From: Nick Hirst
Sent: 21 August 2025 12:04
To: DC Admin
Subject: FW: Castle Hill Hotel - 2024-93494
Attachments: 2018 Transport Assessment.pdf; 2024 Transport Assessment.pdf

From:
Sent: 20 August 2025 14:15
To: Nick Hirst <Nick.Hirst@kirklees.gov.uk>
Cc: Cllr Alison Munro <Alison.Munro@kirklees.gov.uk>; Cllr Paola Davies <Paola.Davies@kirklees.gov.uk>
Subject: Castle Hill Hotel - 2024-93494

Proposed Site Plan 1:200

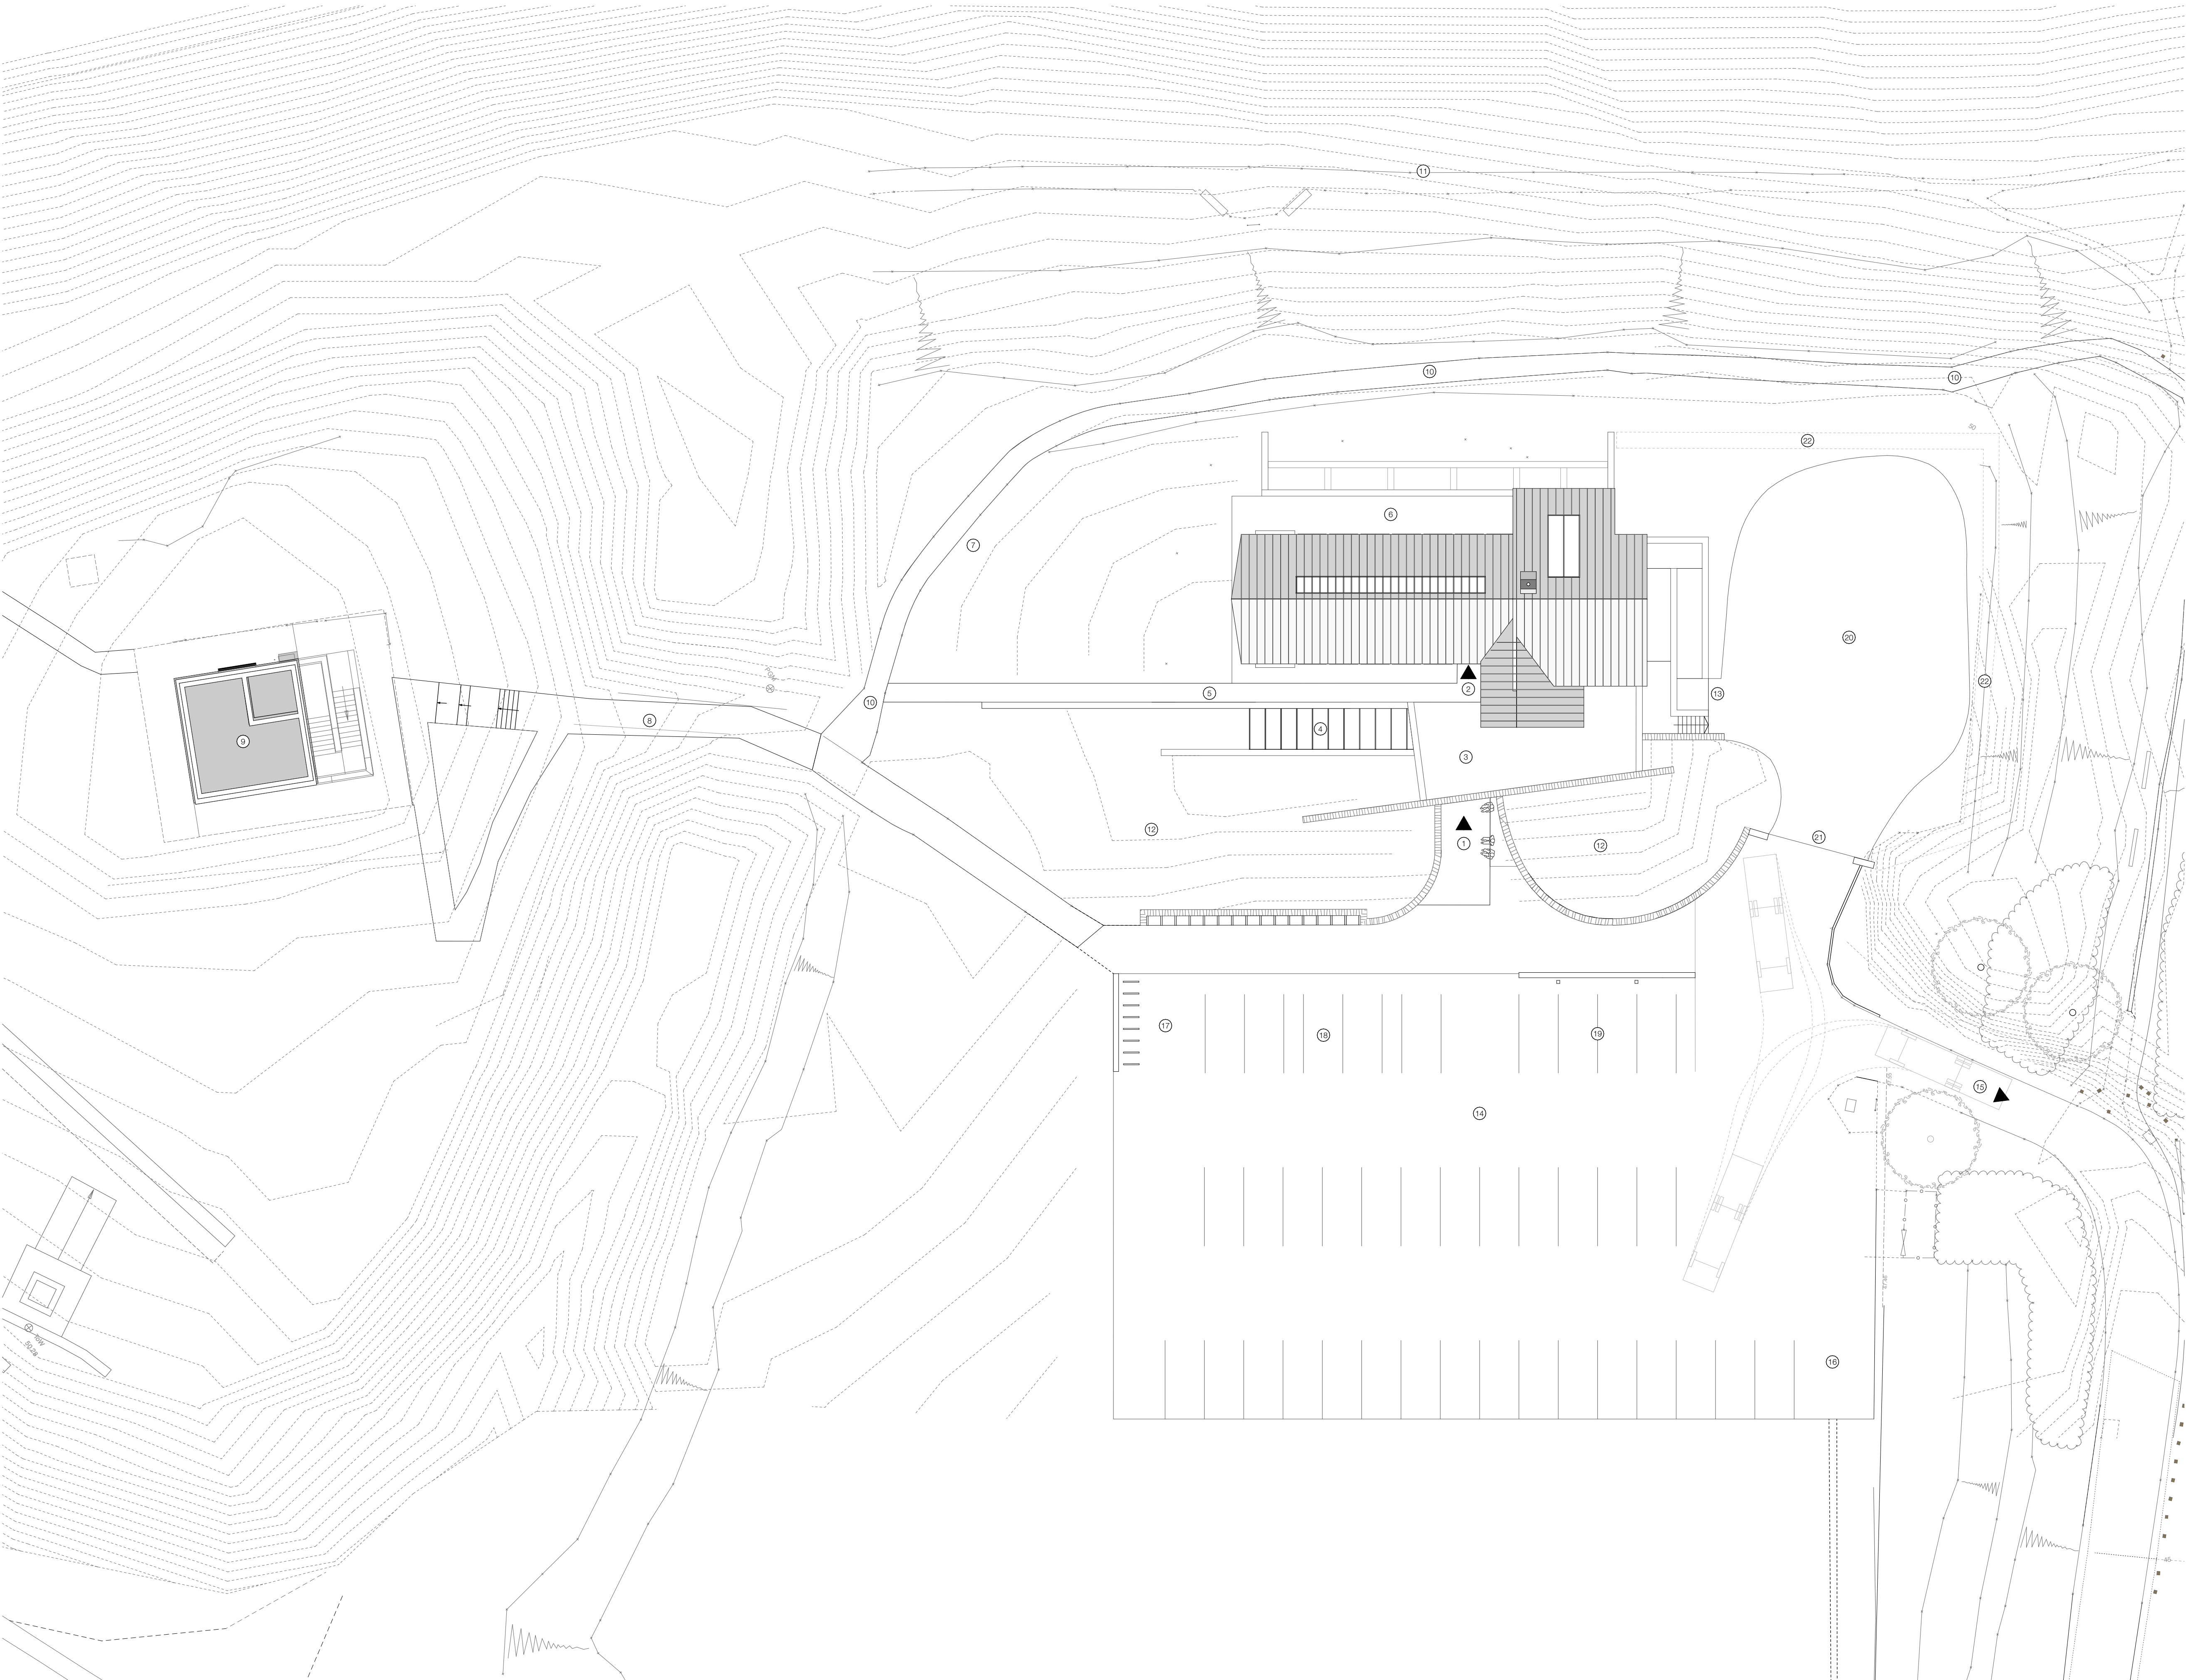
The 2018 application includes documentary support for a parking requirement (estimated max 45) for a significant time period each day. The 2024 application plans incorporate only 37 parking spaces. It should also be noted that the parking identified only appertains to the development - no public parking was included to reflect the requirements of visitors to the site (not making use of the development). Over the last 20 years (despite the absence of facilities) the numbers of parked vehicles have often exceeded 20 and much higher levels on good days.
